Your Ref: OWPC20726
Our Ref: BR/214/18/PL 26-07-2018
Please ask for:
Mr S Davis

Erection of four terraced residential dwellings, garden/cycle storage sheds & associated car parking, utilising the existing access - This application may affect the character & appearance of The Steyne, Bognor Conservation Area & will affect the setting of a Listed Building

Former hotel tennis courts adj to The Royal Norfolk Hotel West Street Bognor Regis

Thank you for your internet representation made on 26th November 2018 which has been recorded as '**an objection**' with the comments as follows:

Drg No: **RNHB.PLAN 1**

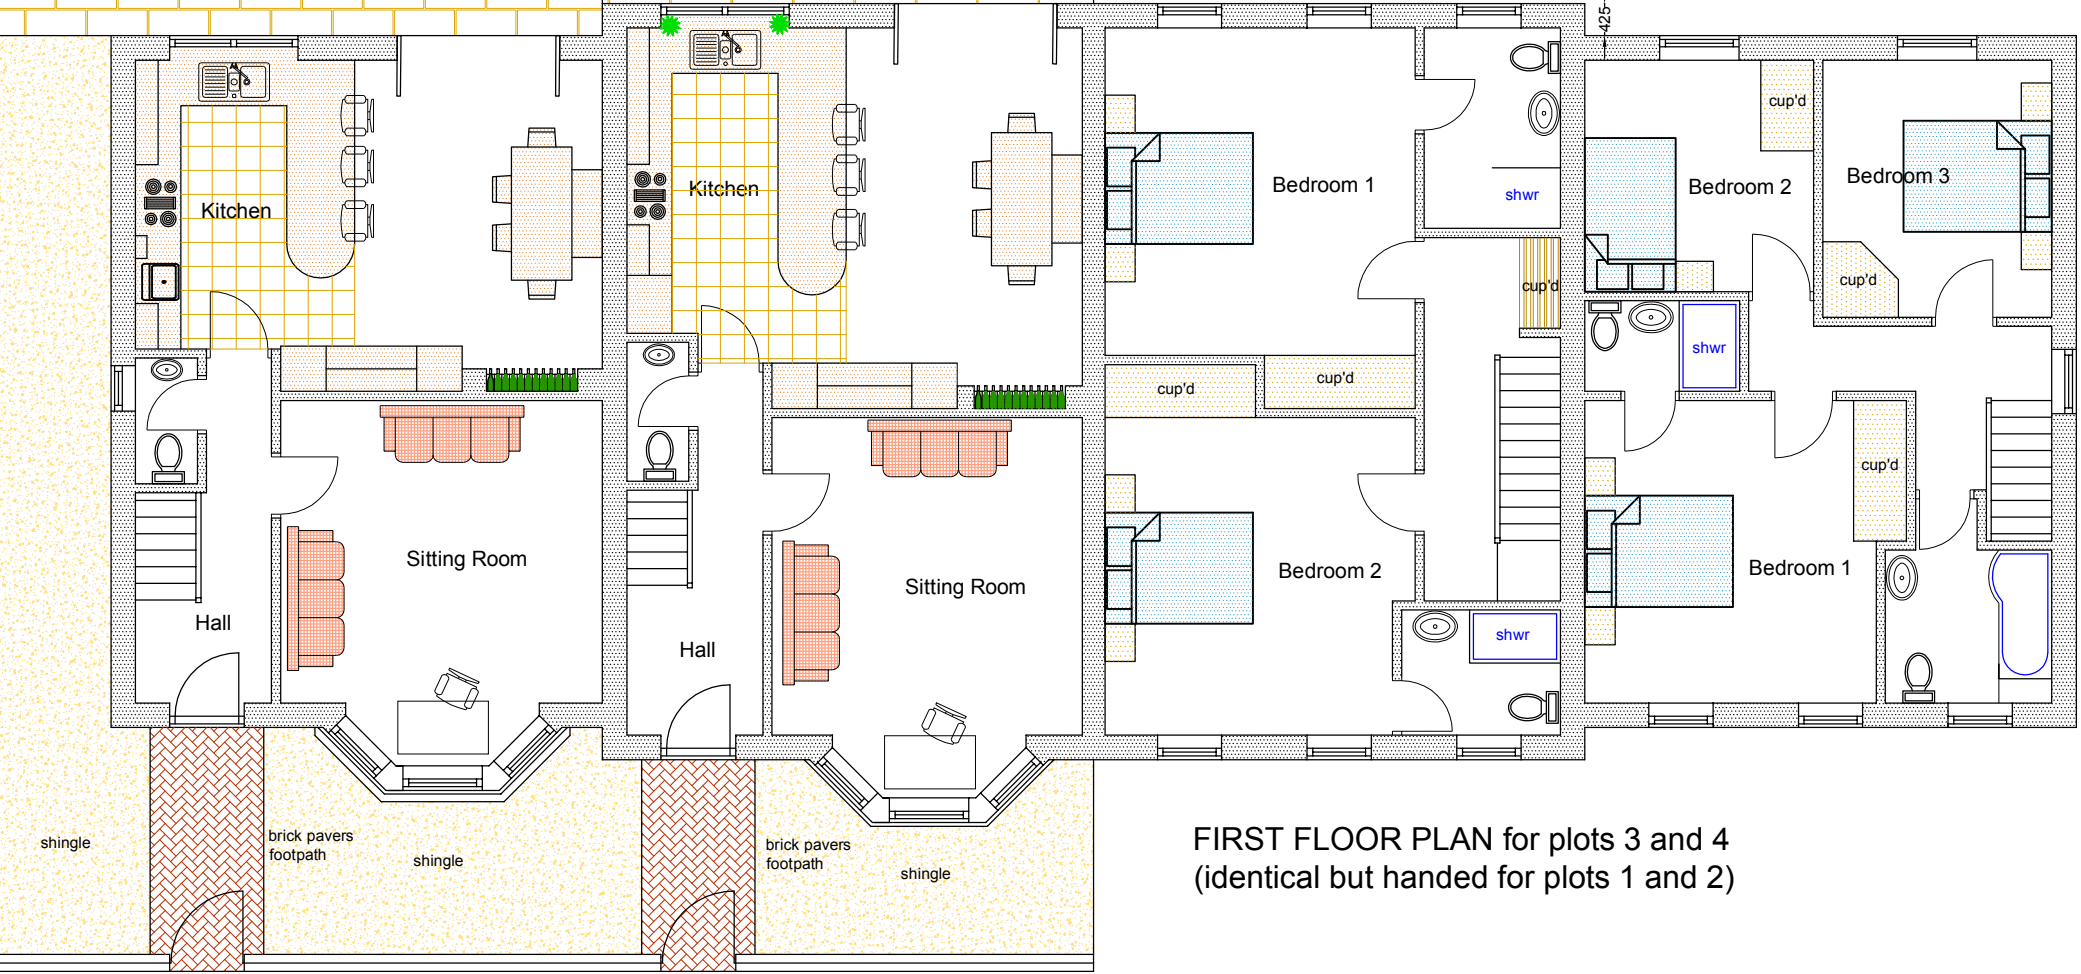
I would further add that it is unclear from the application whether cars can park between the front of the dwellings and the boundary wall.
